M5 Junction 10 Improvements Scheme

Application by Gloucestershire County Council for an order granting Development Consent for the M5 Junction 10 Improvements Scheme

Advice following issue of decision to accept the application for examination – Planning Act (2008) as amended - Section 51

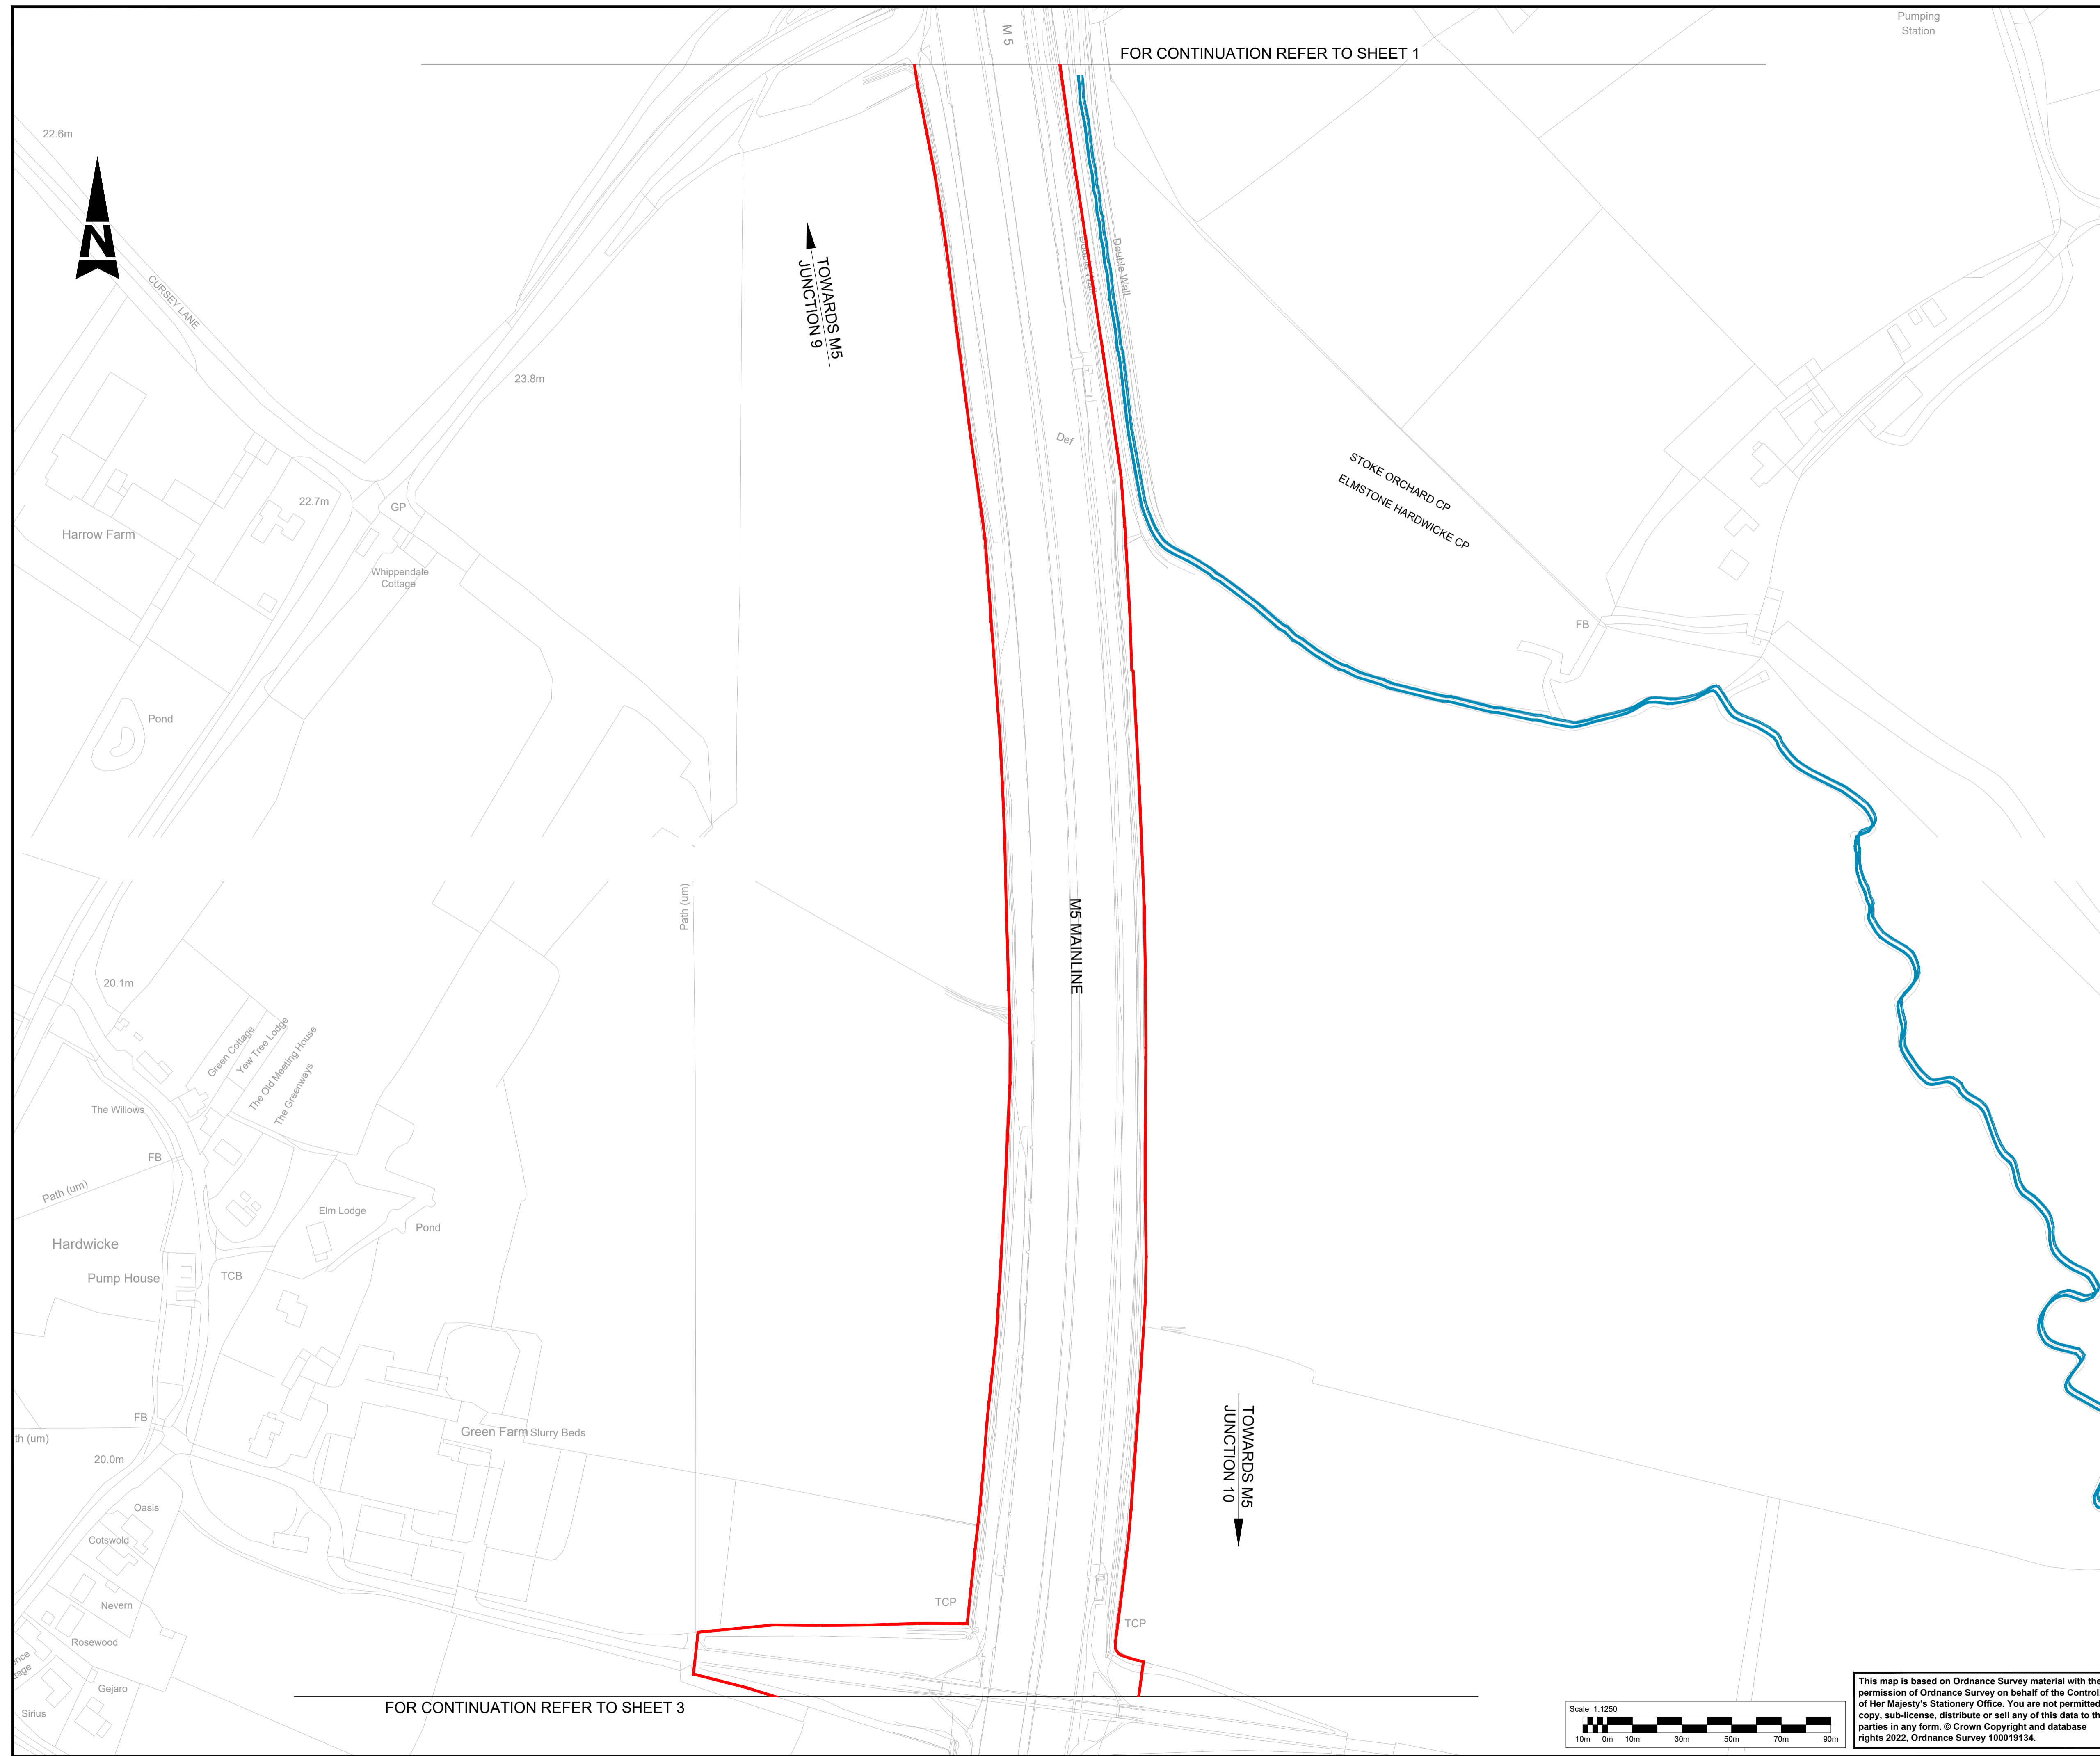
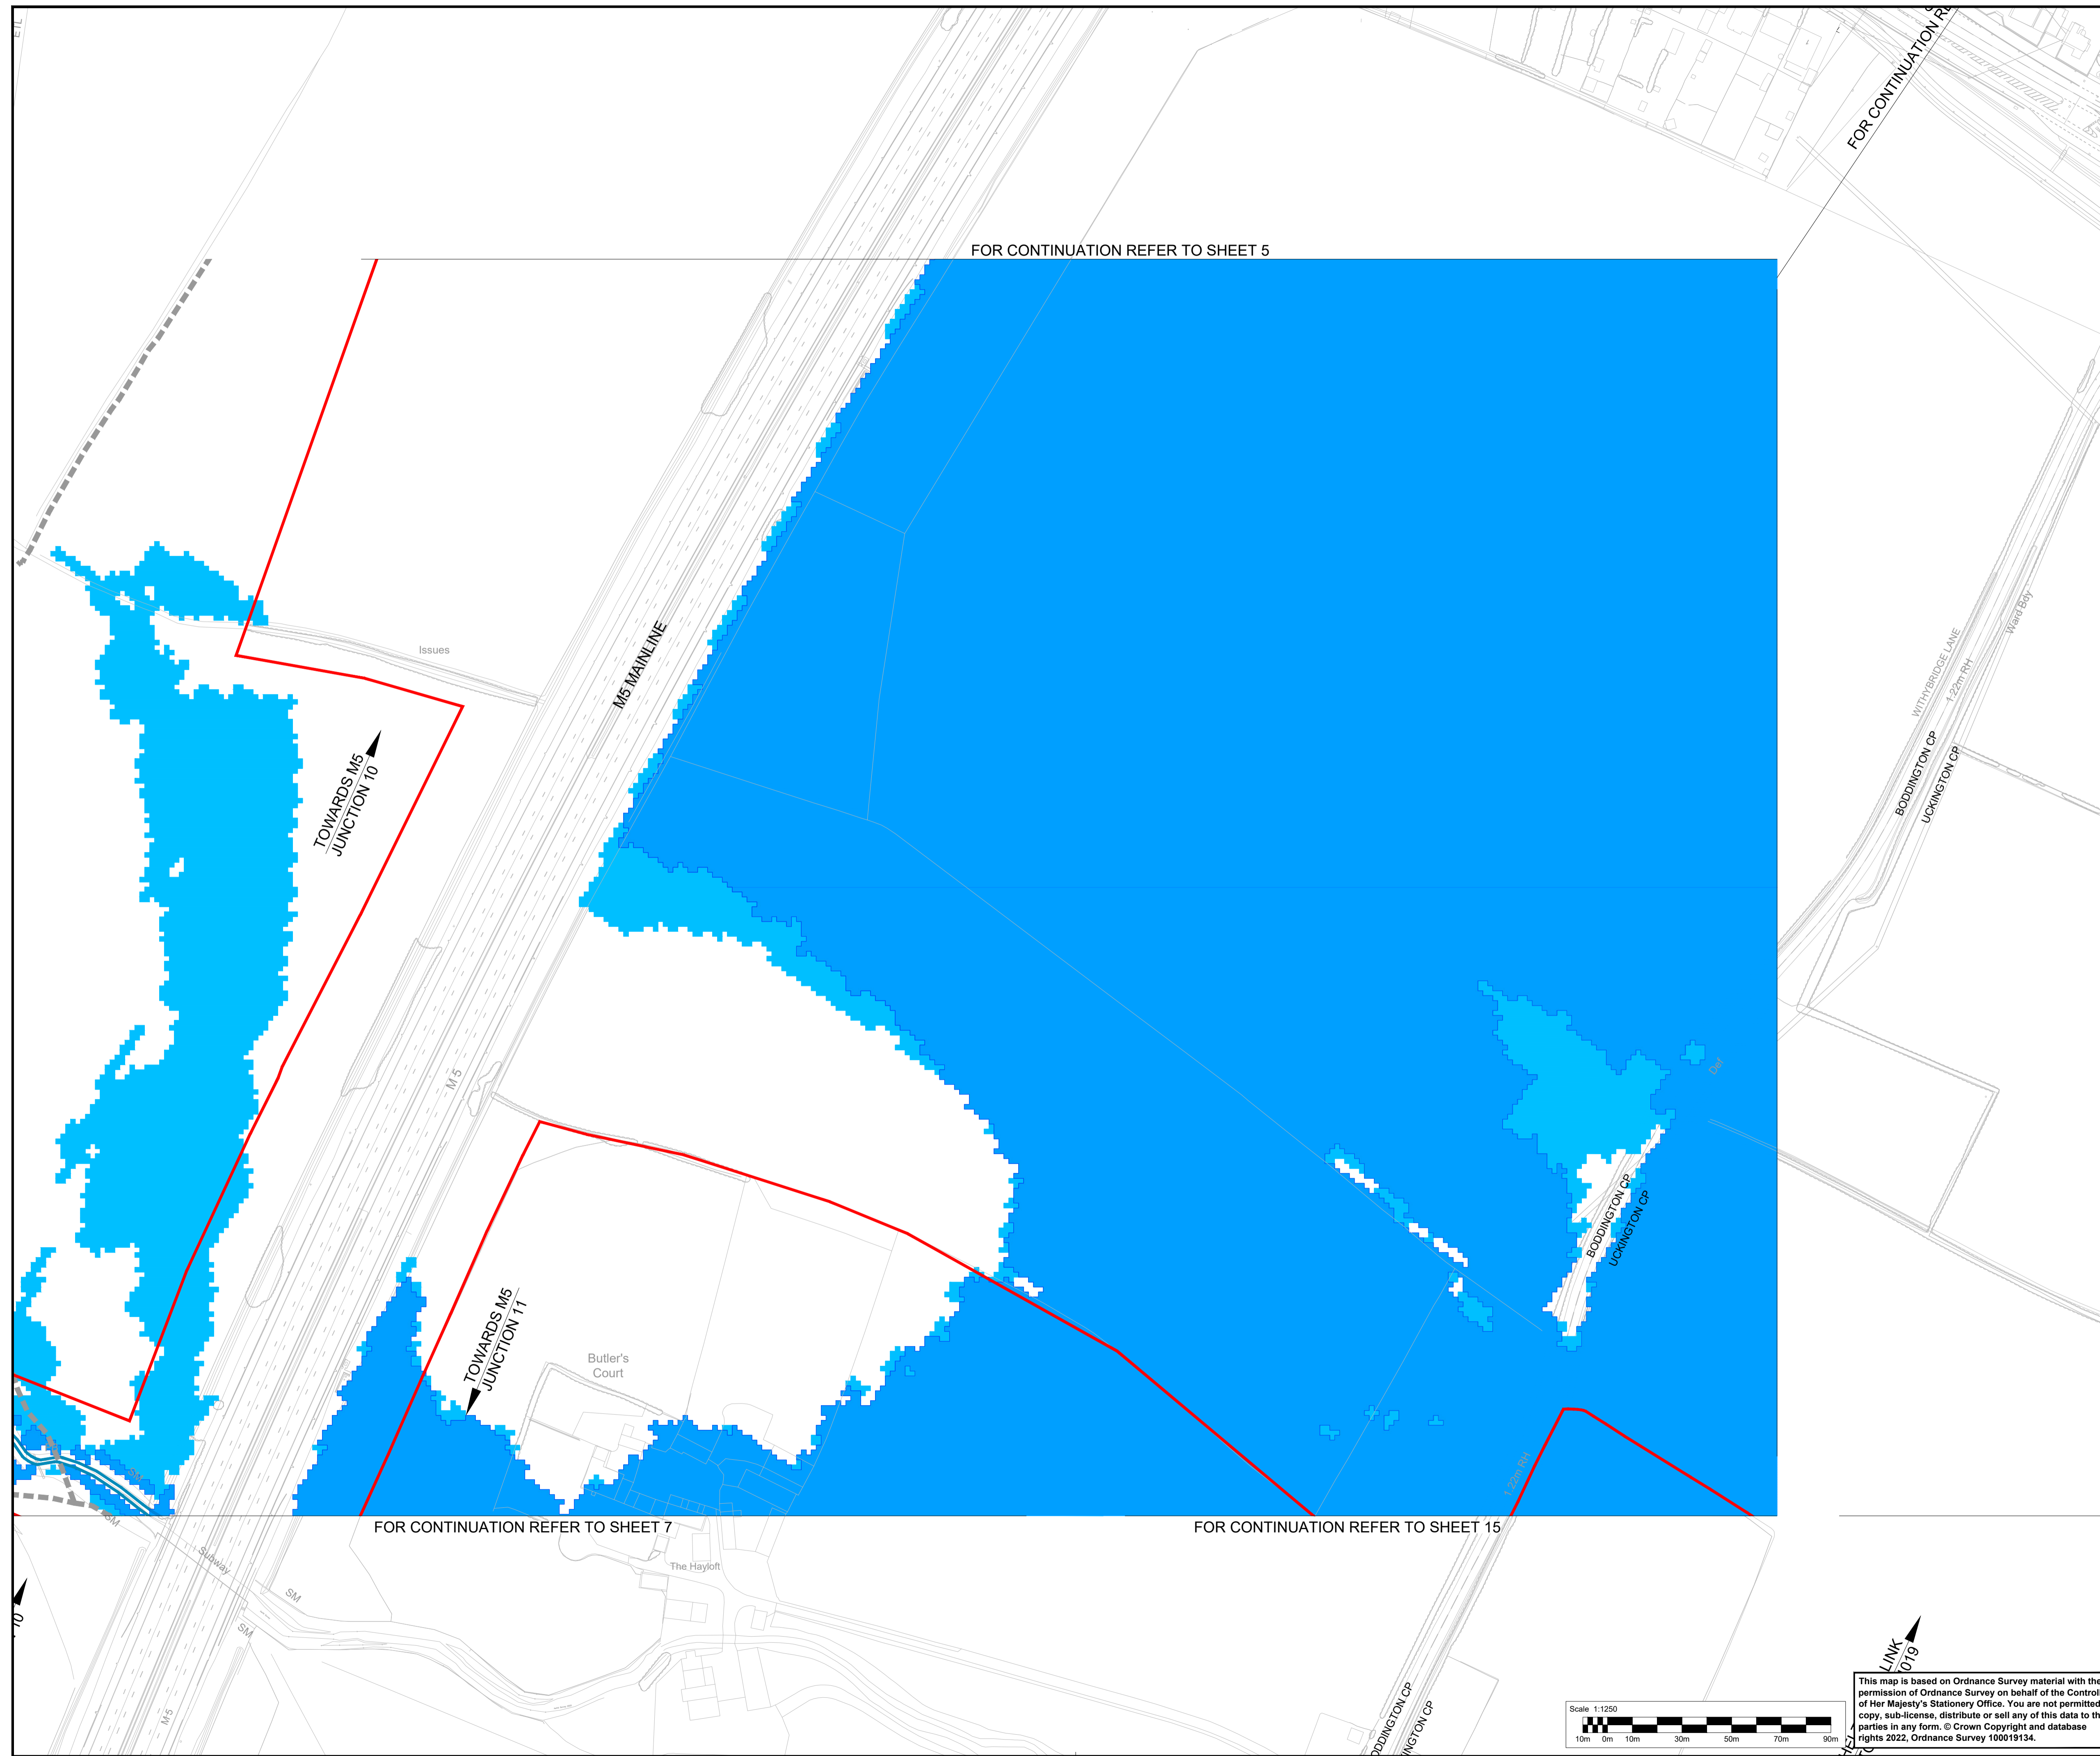
PINS comment: The exported large scale plan has some rendering issues, where the (former) Area of Outstanding Natural Beauty (now known as National Landscape) layer has sporadic horizontal lines that are not shown in the legend. The Applicant is also advised to update the terminology used.

There is also no base map to indicate the geographical location of the identified sites/features.

Applicant response: The Biodiversity Sites and Features Plan (Application document TR010063/APP/2.11) has been updated and changes made to the rendering of the green shaded area, and to the labelling of the Landscape area. The Cotswolds AONB has been amended to Cotswolds National Landscape.

A base map has also been included.
